ARCHITECTURAL DESIGN STATEMENT ADDENDUM

Prepared in response to DPHI request for further information dated 16 February 2026.

16-24 LORD STREET & ROSEVILLE 21-27 ROSEVILLE AVENUE

MARCH 2026

1 NORTH ELEVATION (ROSEVILLE AVENUE)
SCALE 1 : 300

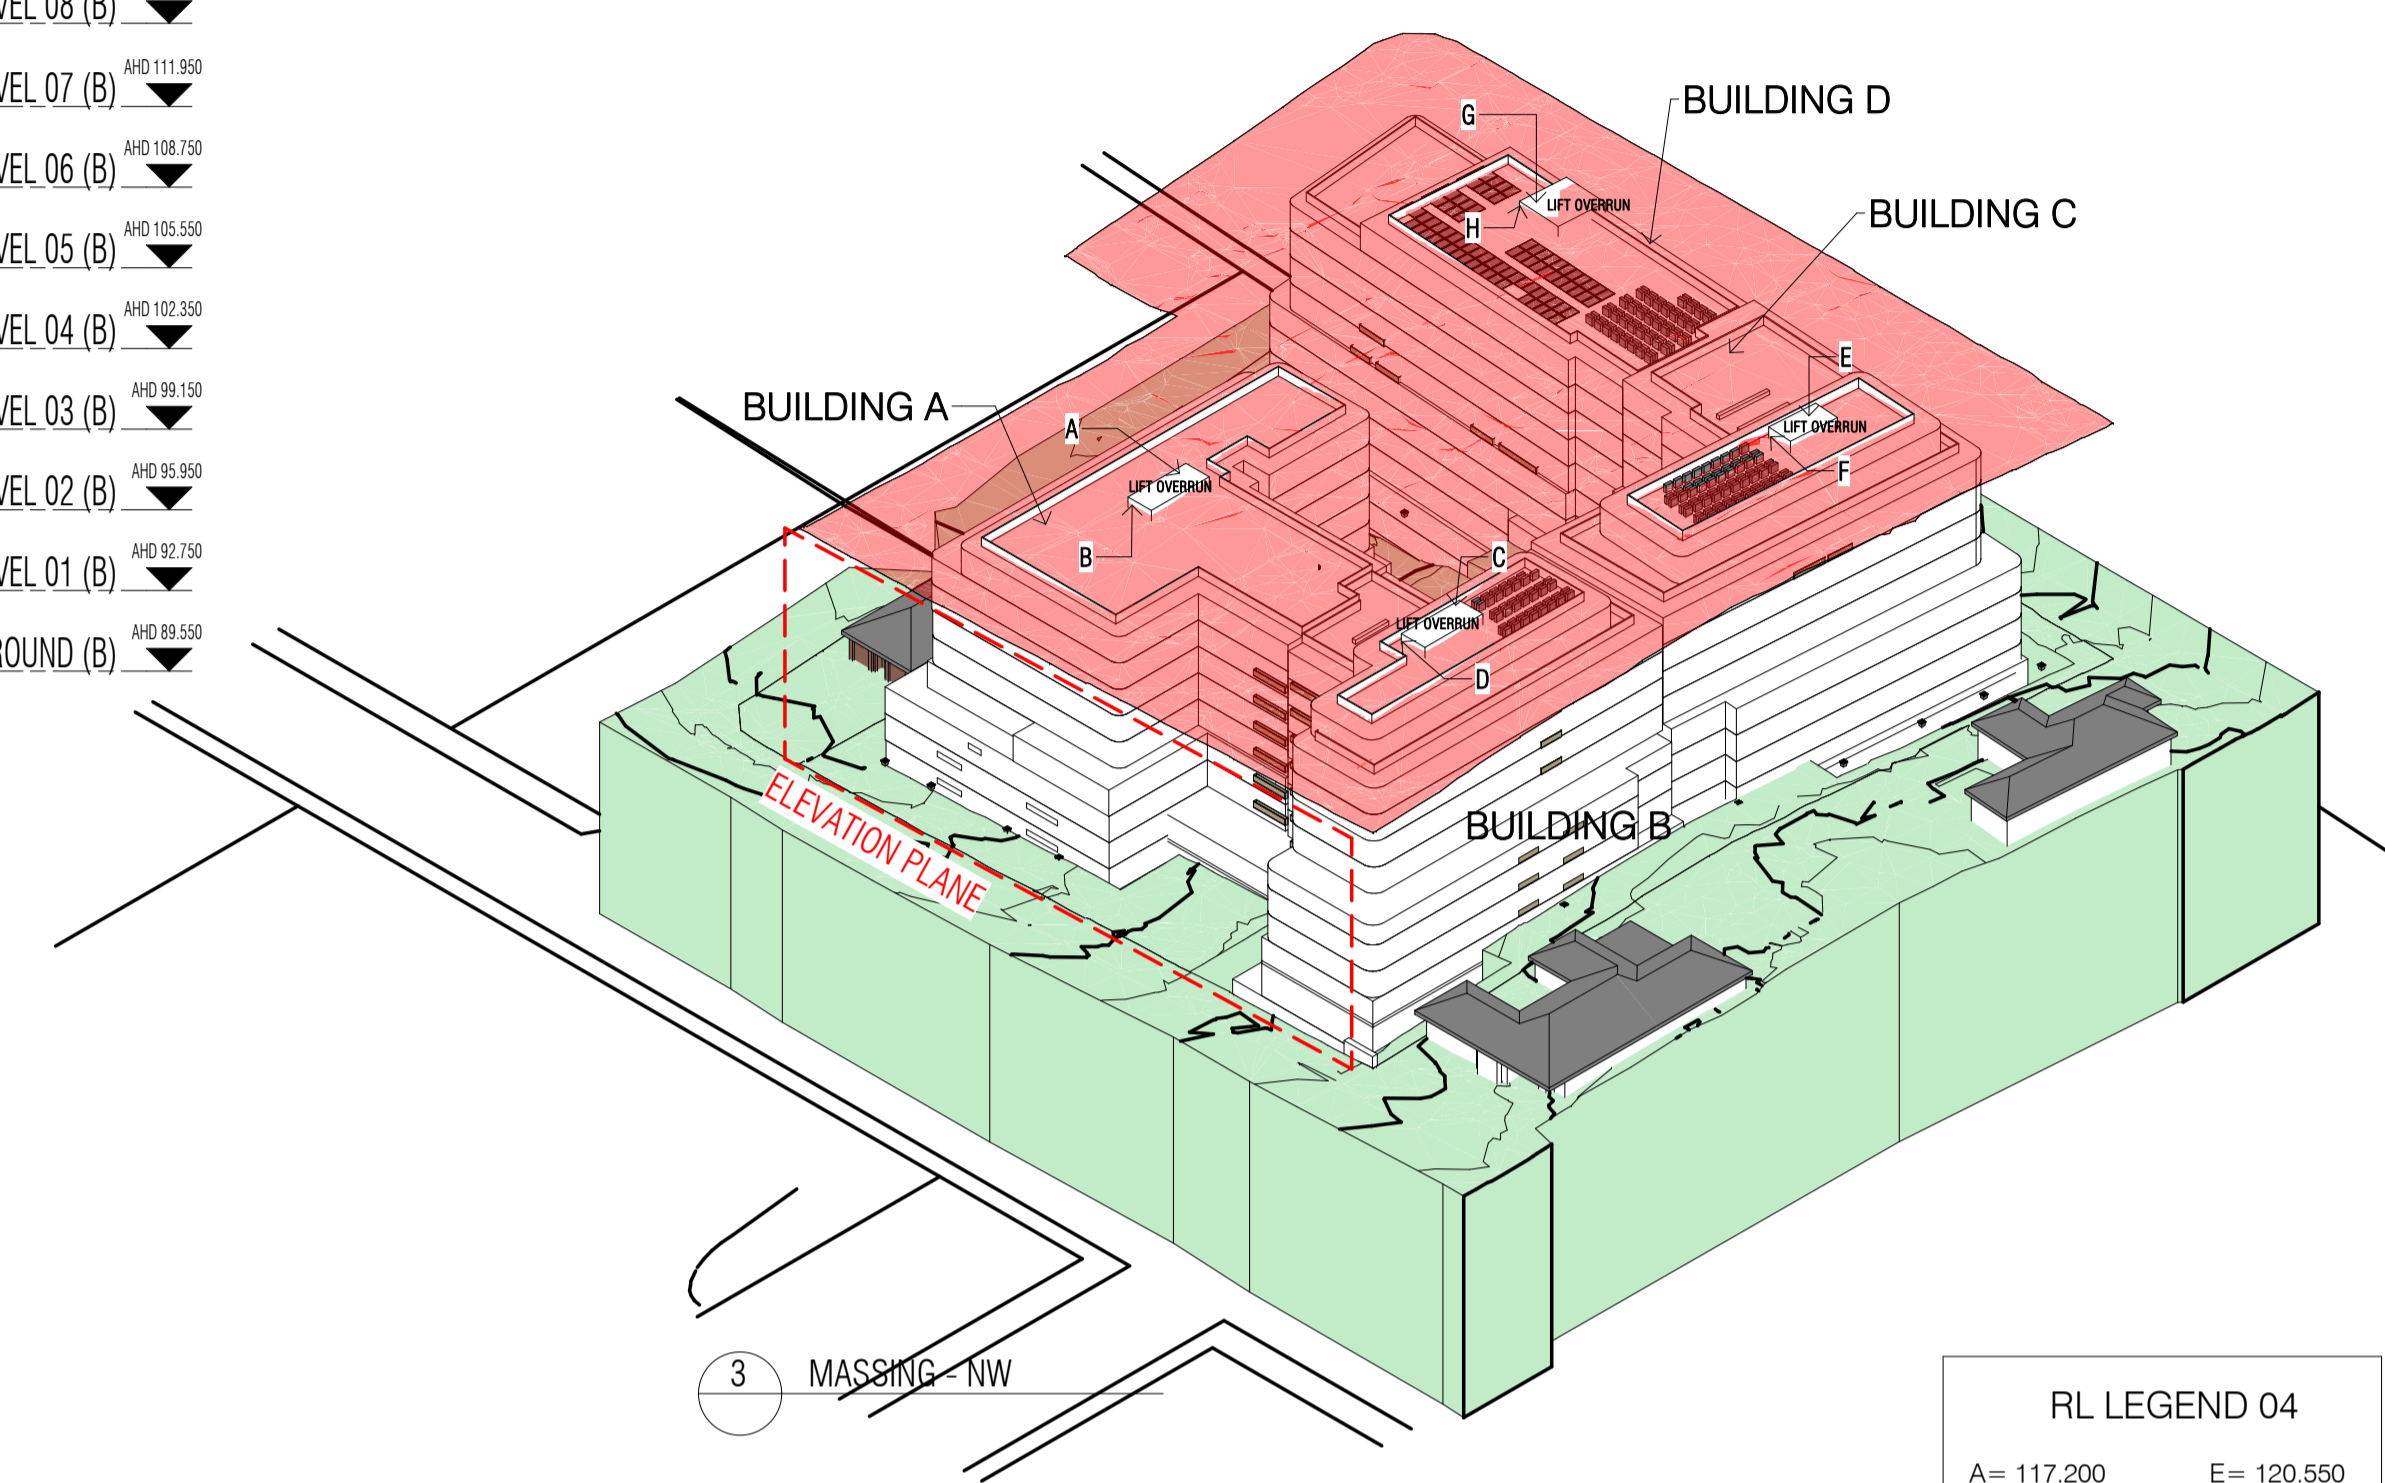
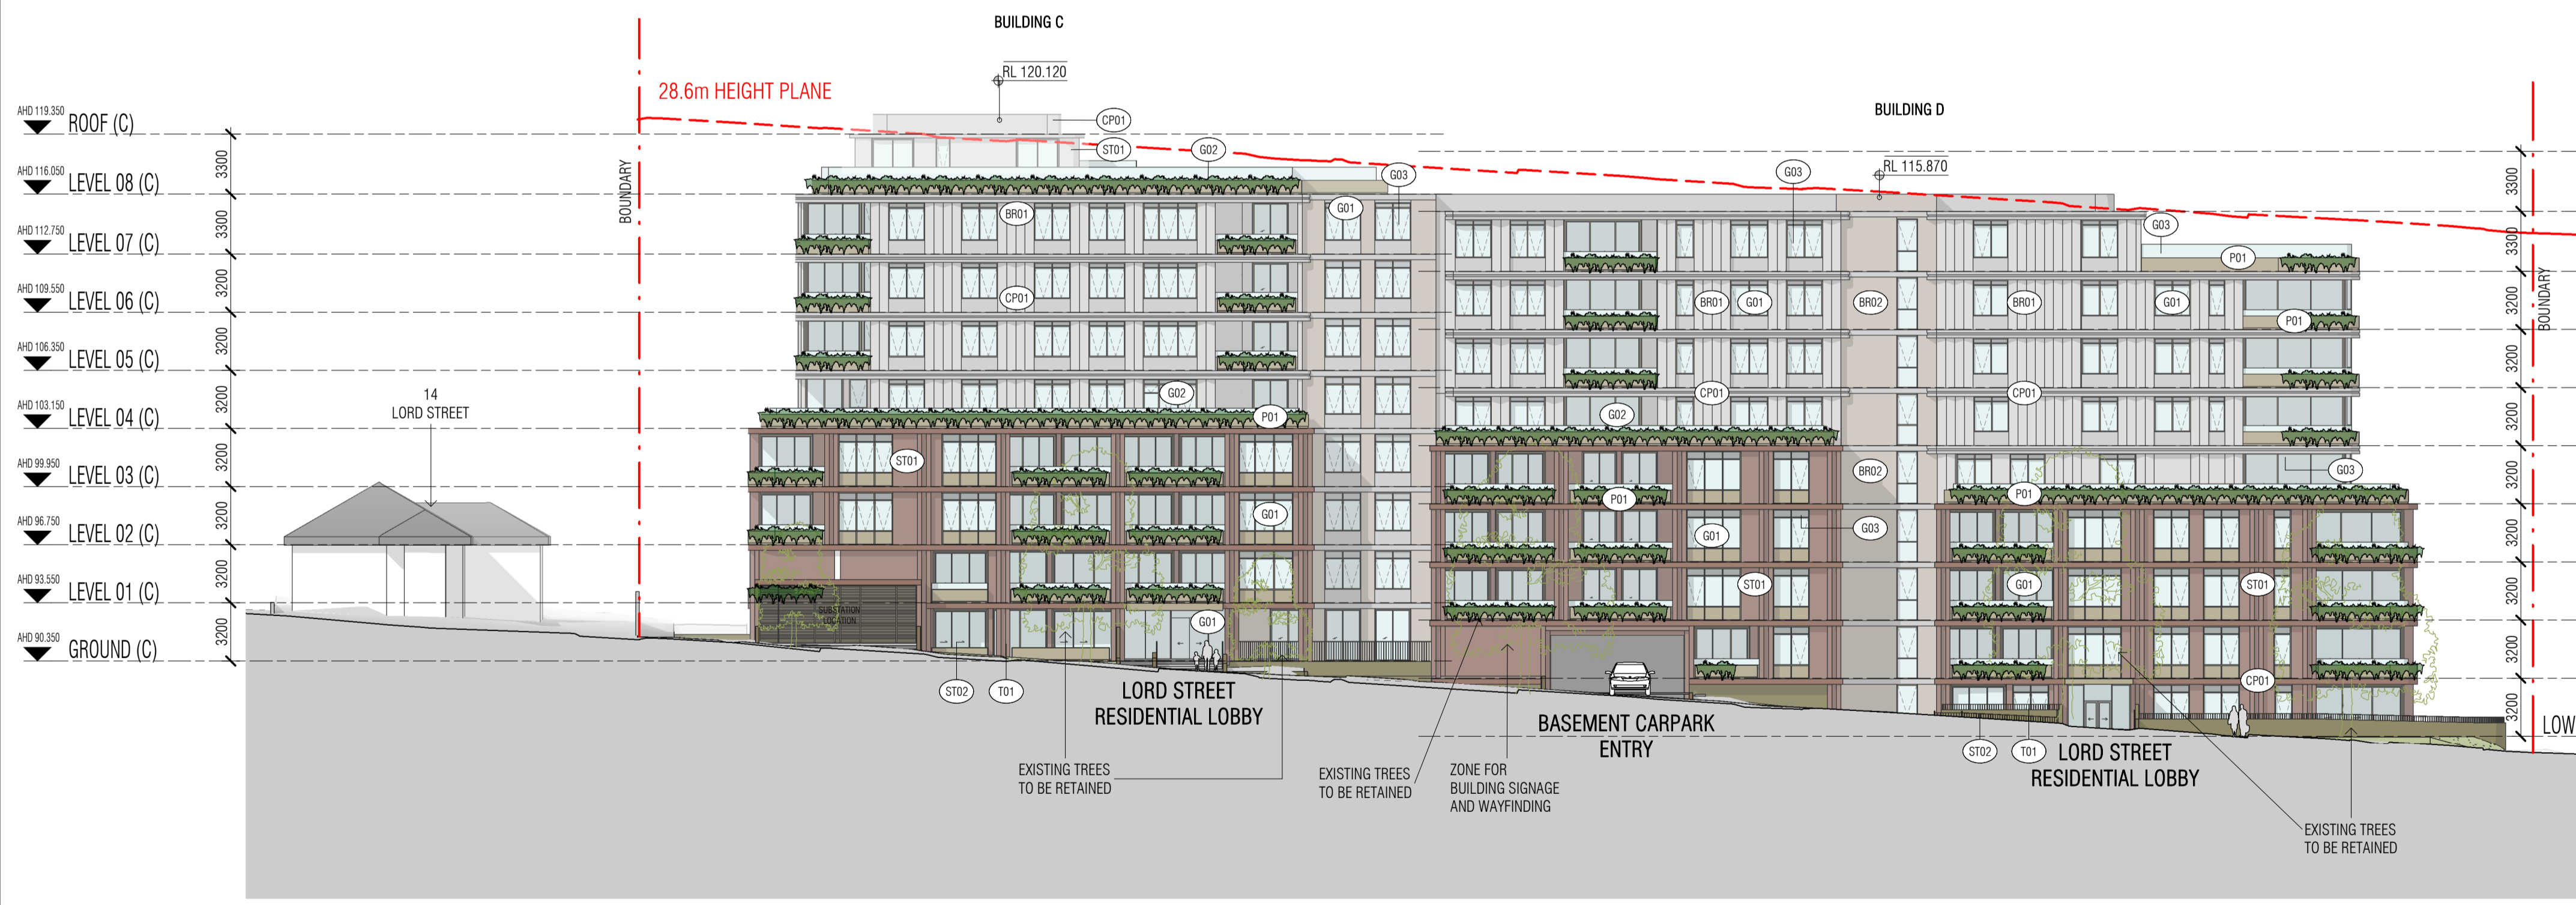
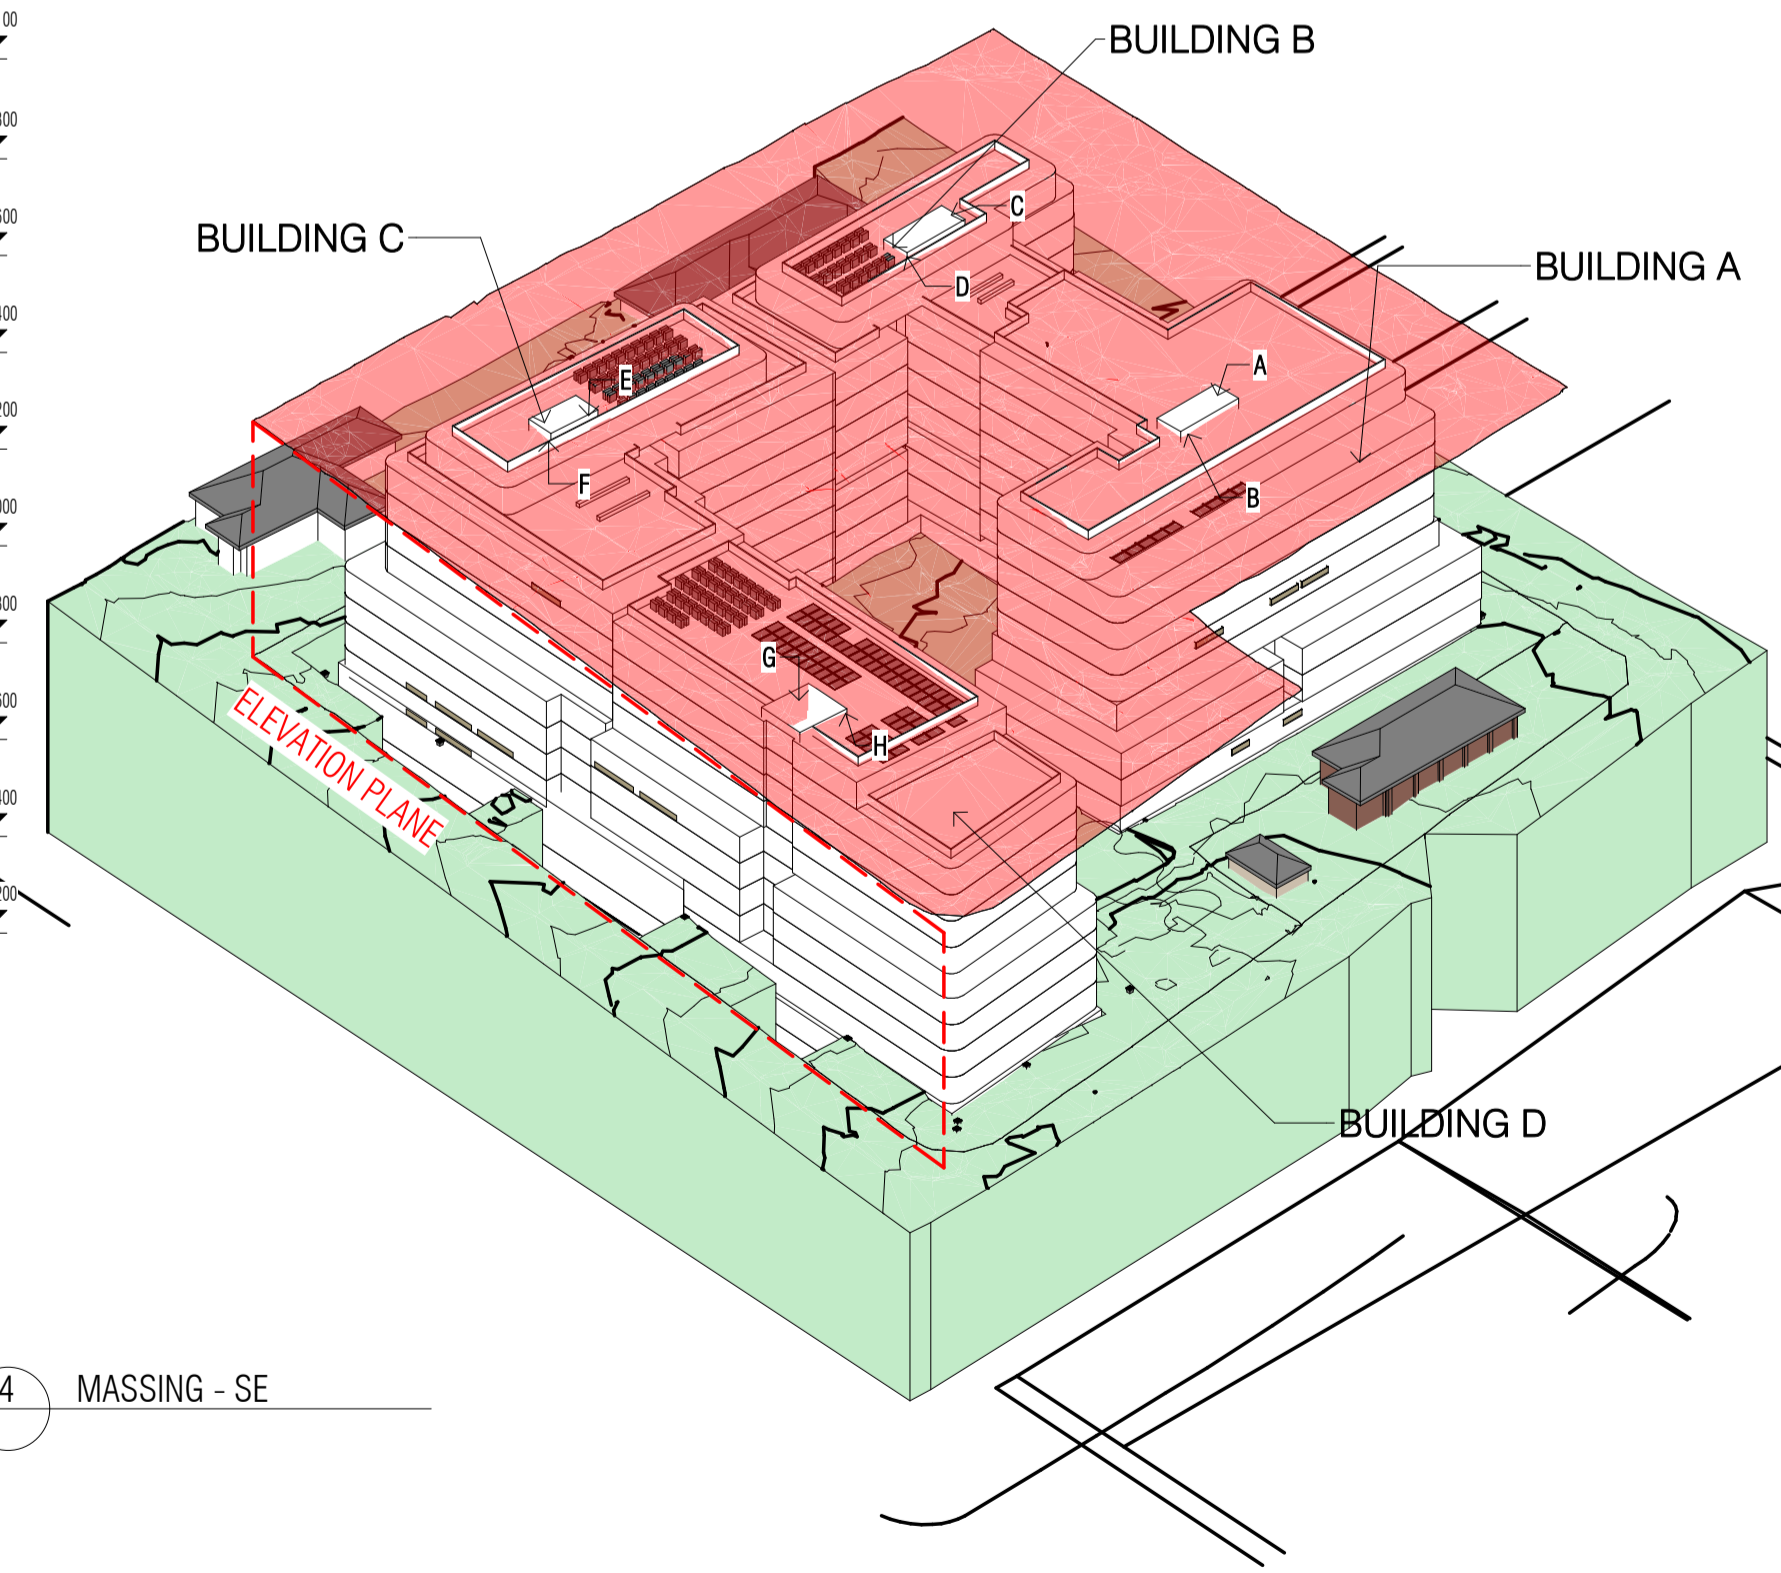
1.1 The proposed heights of the podiums should reflect the existing topography and provide a transition in scale to the adjoining context, particularly the Scout Hall. The Department recommends that you reduce and step the podium heights of Building A and D to further improve the relationship with the streetscape.

1.4 Provide details of height and design of all awning and utilities (including hydrant booster cabinets) facing Roseville Avenue and Lord Street.

1.5 Incorporate the recommendations of the wind study, as updated by the wind impact assessment addendum, into the architectural plans.

The design has been refined to allow for a further reduction in the eastern portion of Building A from 4 to 3 storeys to create a stepped podium form that follows the sloping topography of Roseville Avenue while reducing the visual bulk of the building when viewed adjacent to the lower scale Scout Hall building adjacent.

The eastern end of Building D has similarly been reduced from 5 to 4 storeys to accentuate the stepped form of the Lord Street elevation.

The height and design of awning and utilities, wind mitigation measures and specified in the Wind Impact Assessment Addendum Report, have been added to the architectural plans.
